# Charlotte Department of Transportation

## Memorandum

**Subject:** Rezoning Petition 08-067: Located on the east side of Colwick Road  
between Chiswick Road and Greenwich Road  
(Revised 4/18/08)

TITLE:
CONCEPTUAL SITE PLAN

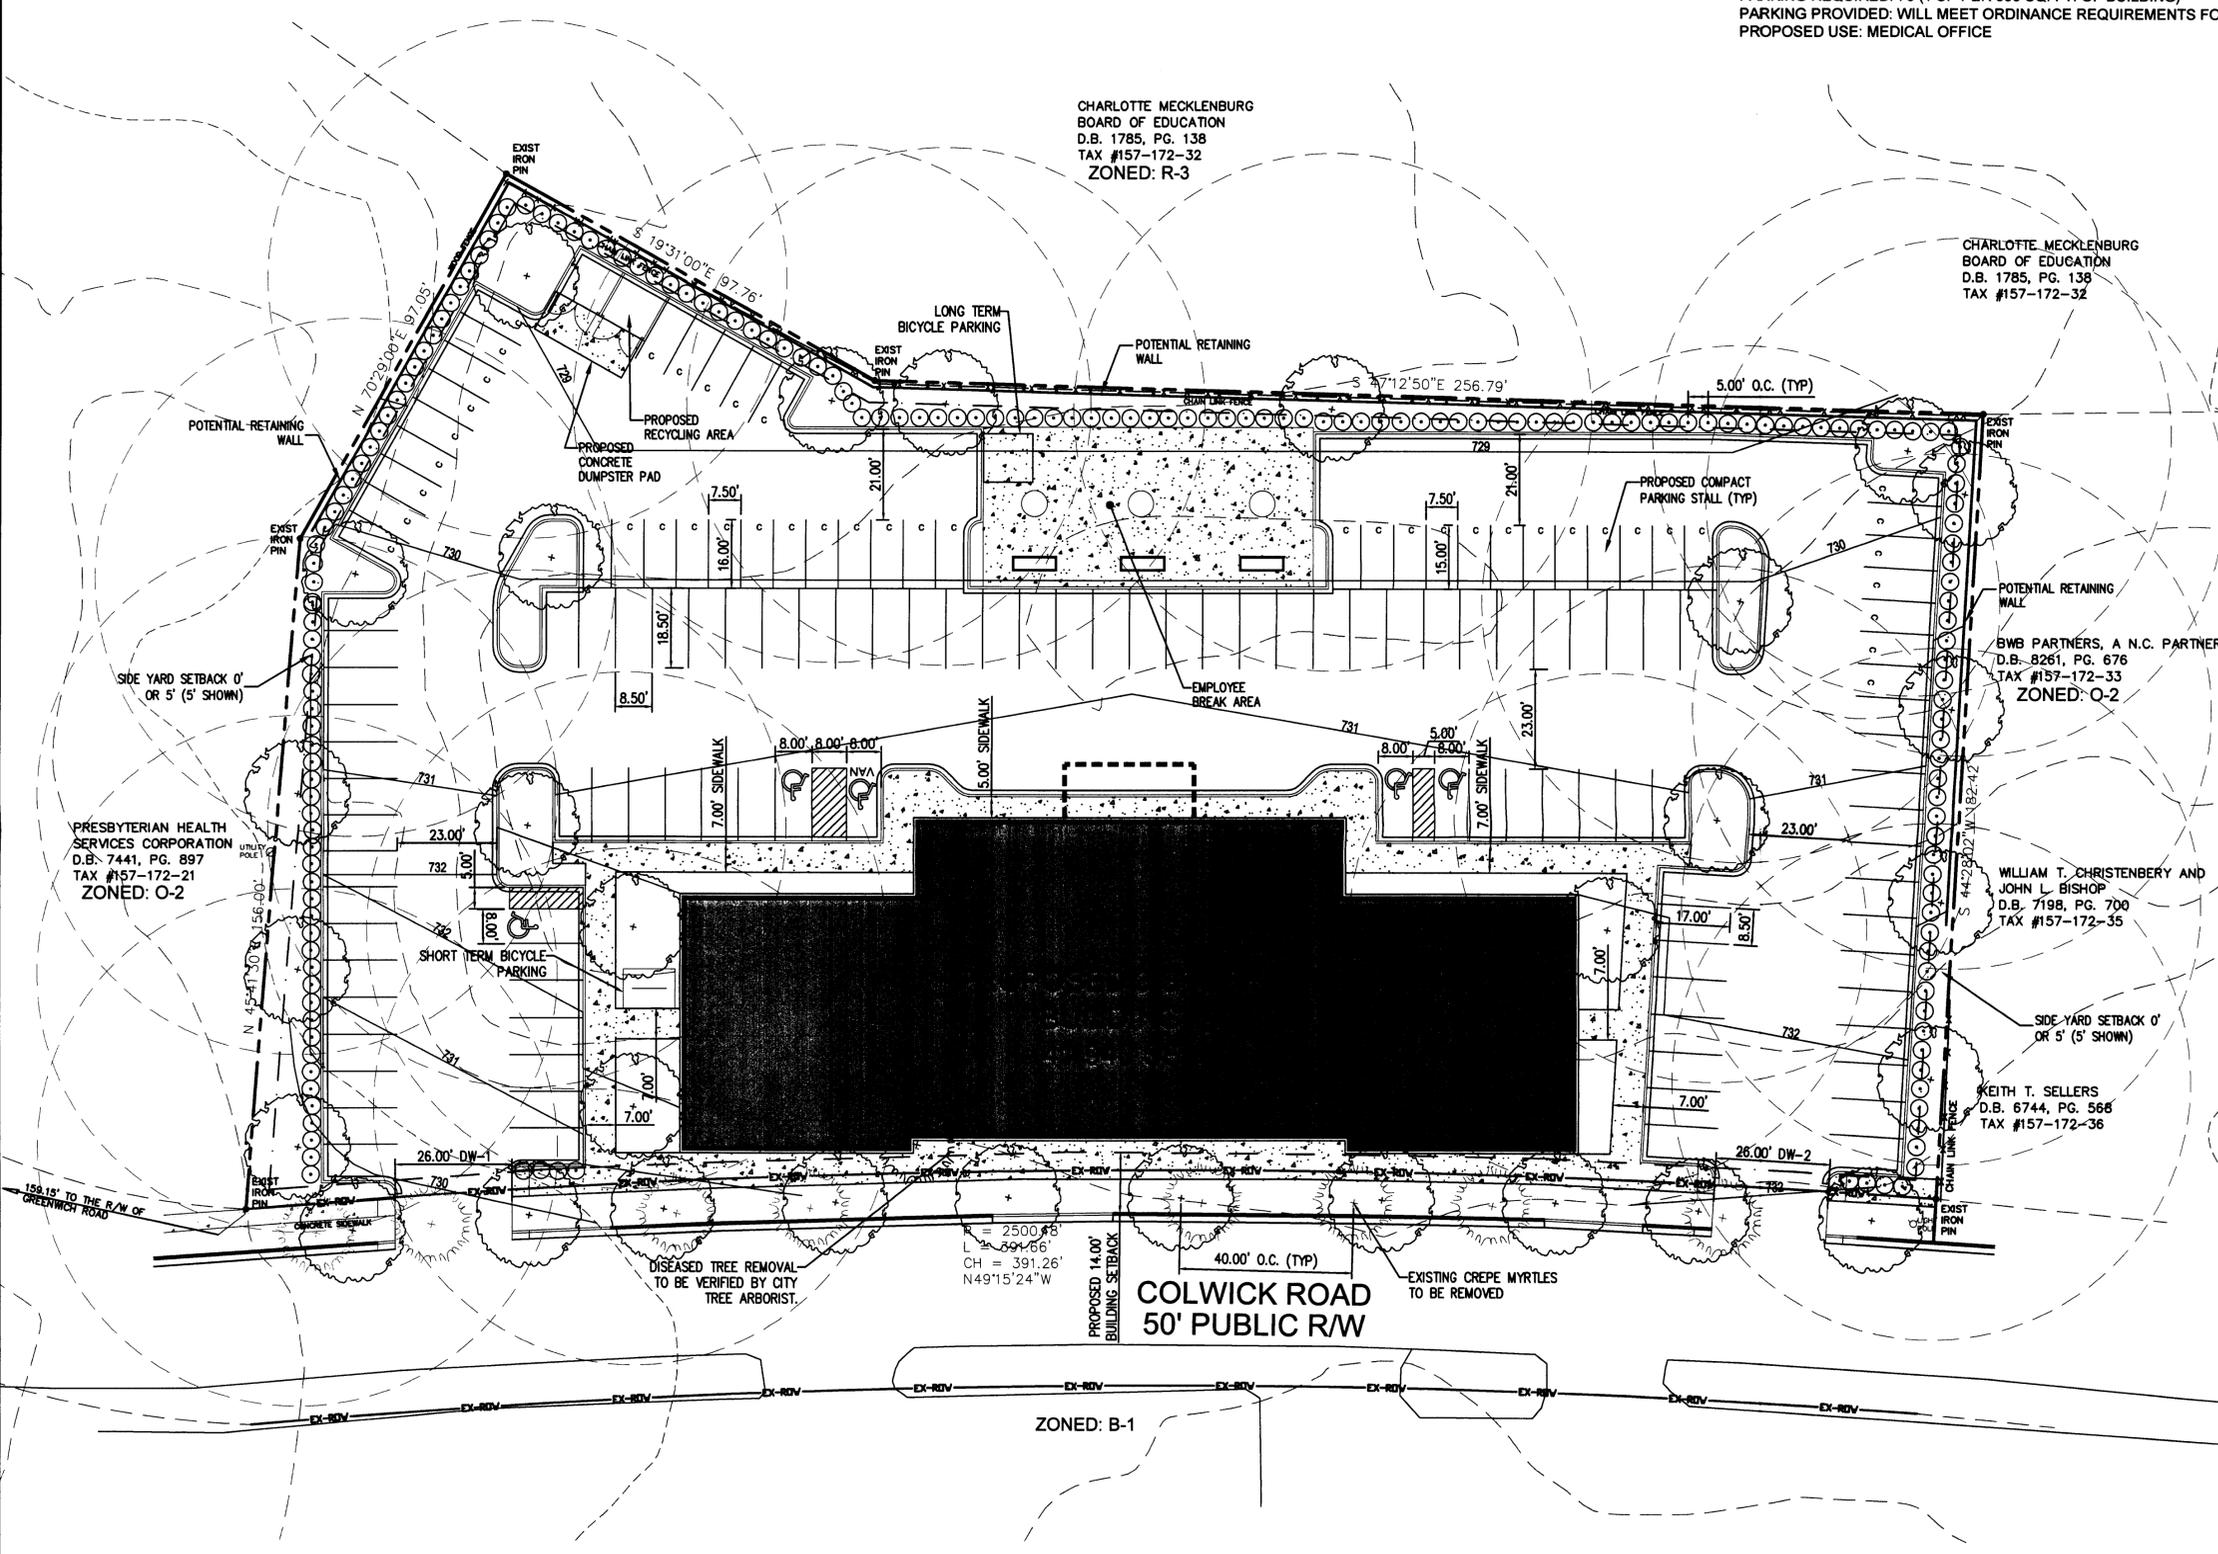
1. According to the adopted Urban Street Design Guidelines (USDG), the preferred/typical block spacing in designated Centers is 500 feet. The current intersection spacing on Colwick Road between Chiswick Road and Greenwich Road is approximately 800 feet. Although we do not believe that a new public street is needed at this particular location to provide better vehicular connectivity, we do think that a pedestrian/bike path connection is needed to provide better access to Cotswold Elementary School for students accessing the school from North Sharon Amity Road. This pedestrian/bicycle connection would help to separate

students/bicyclists from the only vehicular entrance to the school via Greenwich Road. We request that the petitioner/developer contact CMS concerning the connection, provide a 10-foot easement, and construct a 10-foot concrete pedestrian/bicycle path to Cotswold Elementary School at a location that is mutually acceptable. (*Previous review comment*)
